**Application Number:** P1401/22/APP

**Location:** Hillyfields Nurseries Tewkesbury Road Newent

**Proposal:** Application for approval of reserved matters (Appearance, Landscaping, Layout and Scale) relating to plot 3 of planning permission P0520/17/OUT

### **Non Material Amendment No. 1 – Clarification of external materials used**

TITLE: Proposed Site Plan A1

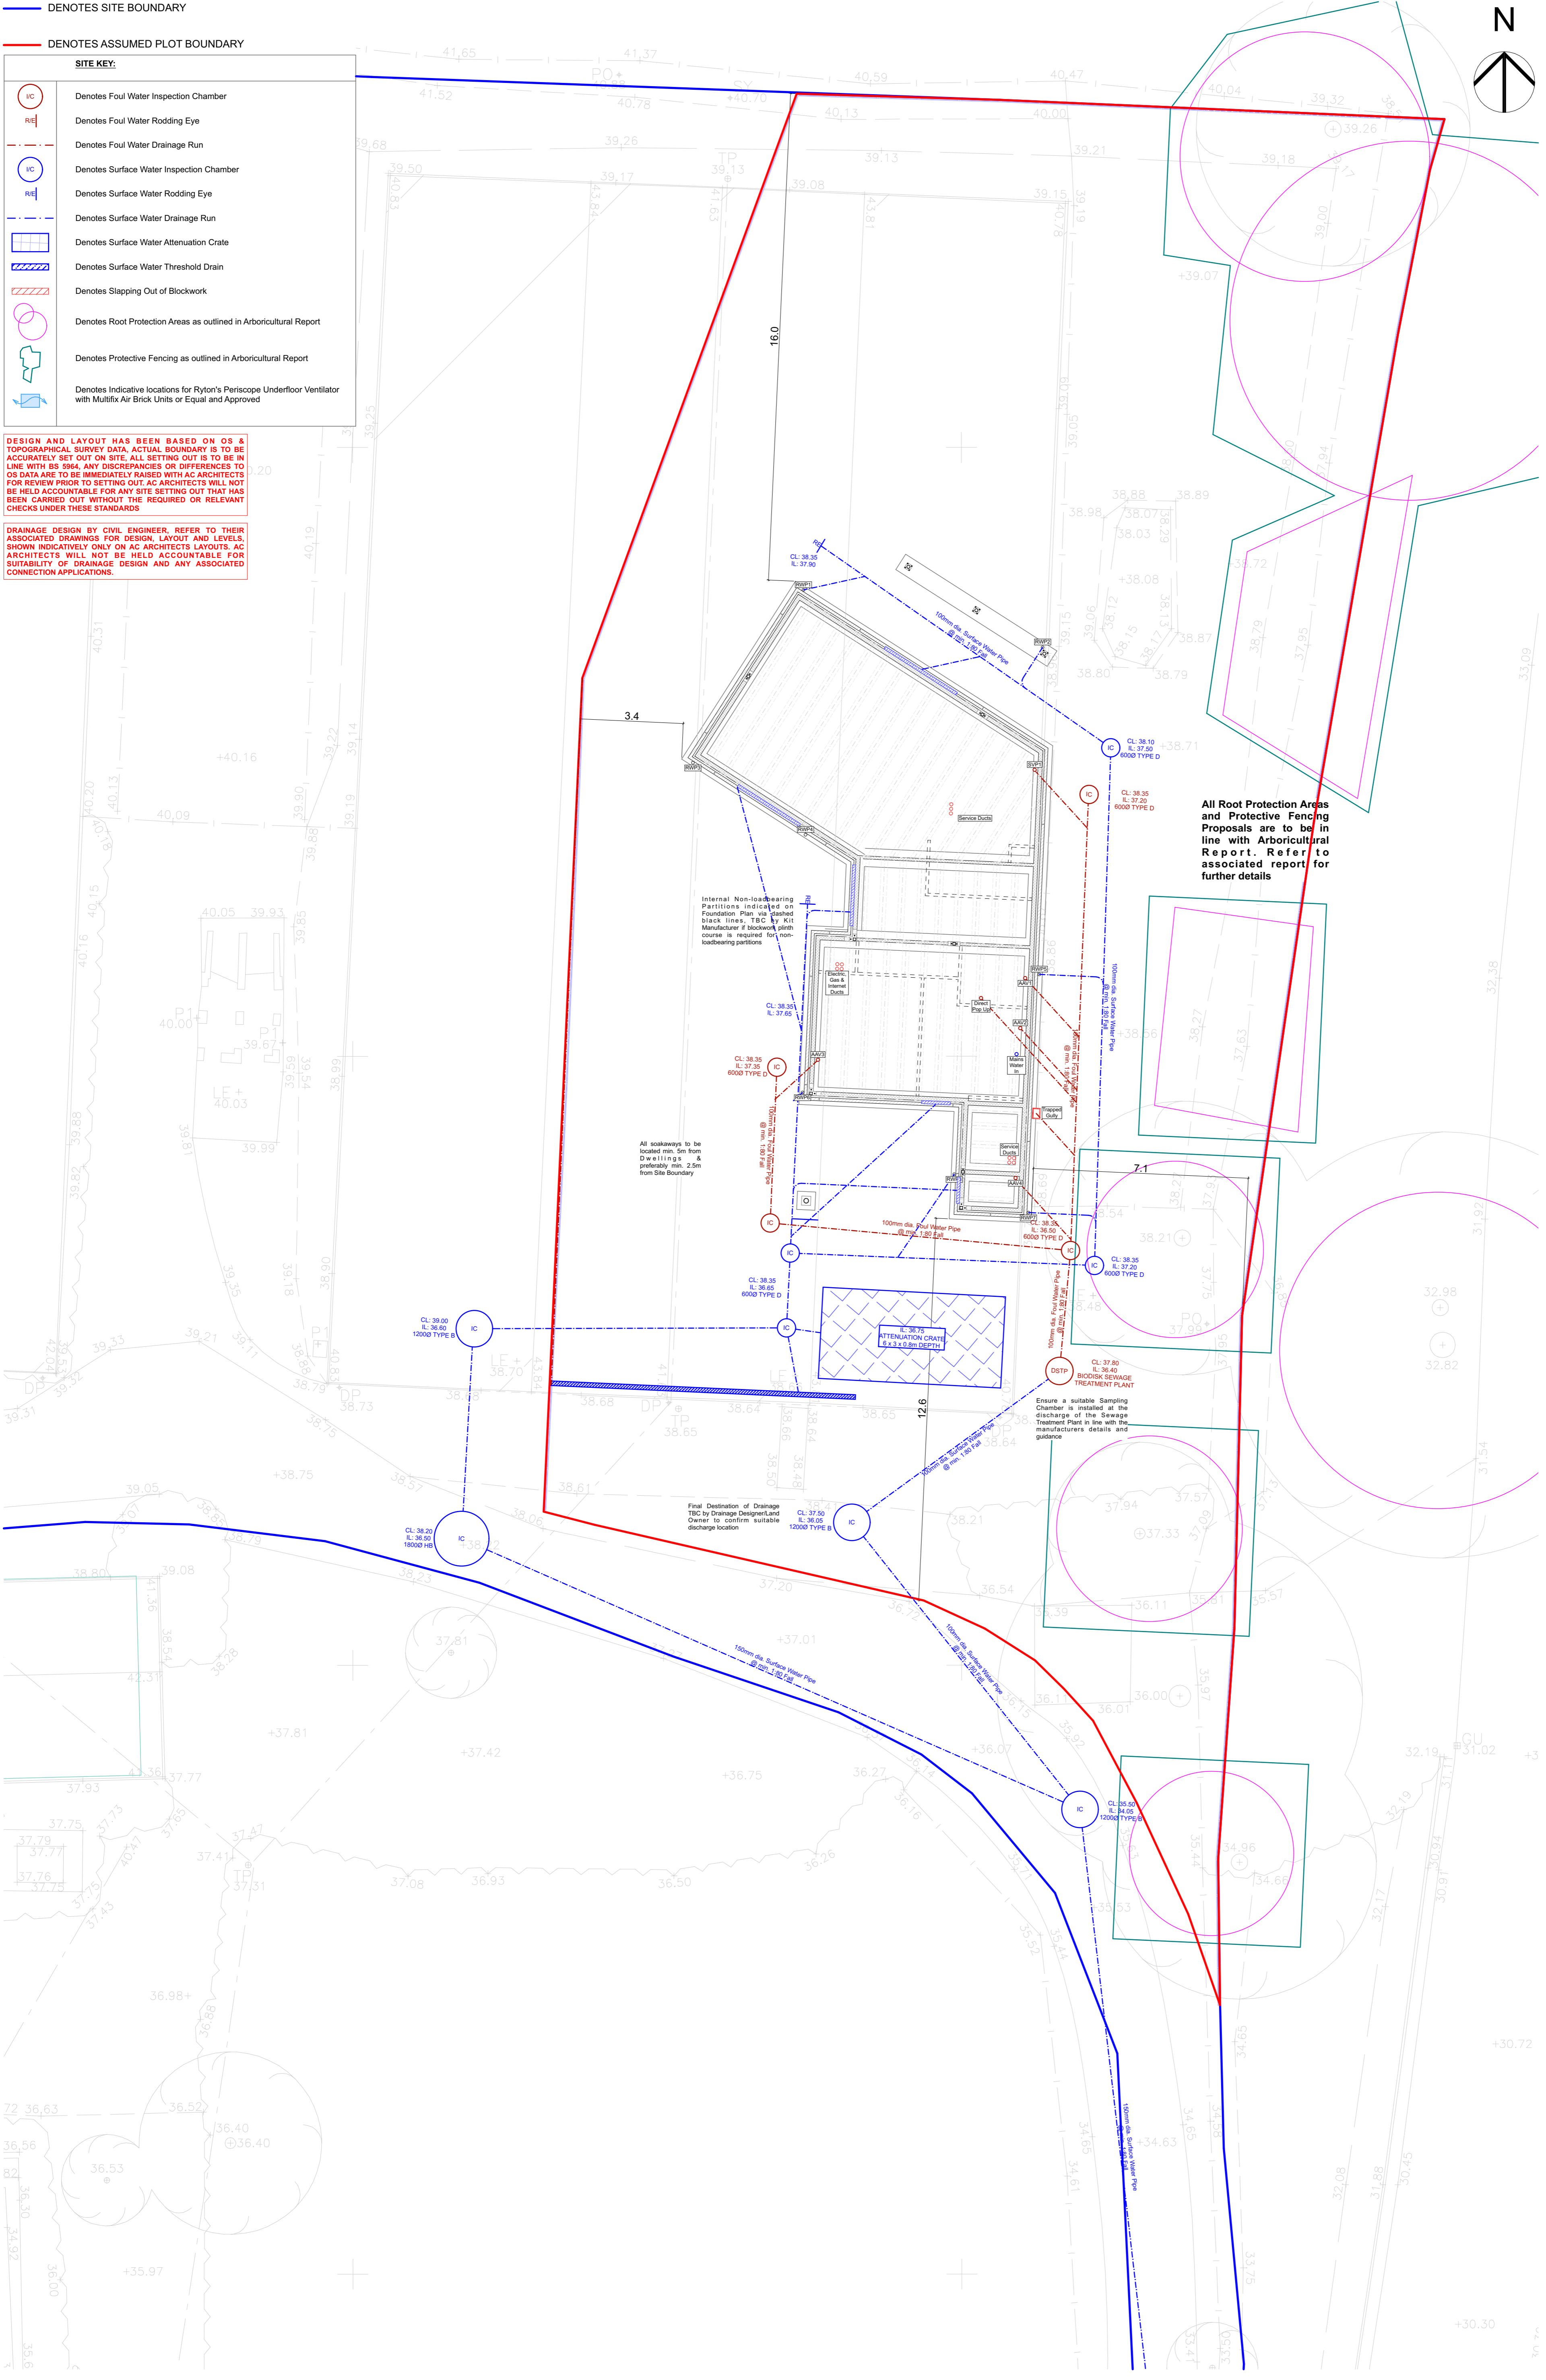
### **Non Material Amendment No. 2 – Updates to surface drainage attenuation**

The previous scheme included a single attenuation tank for all three plots within the original planning permission. Each plot will now have its independent attenuation tank. The size and location of the tank previously indicated on Plot 3 has therefore reduced in size and shifted away from the drive as attached drainage drawing and rainwater calculations.
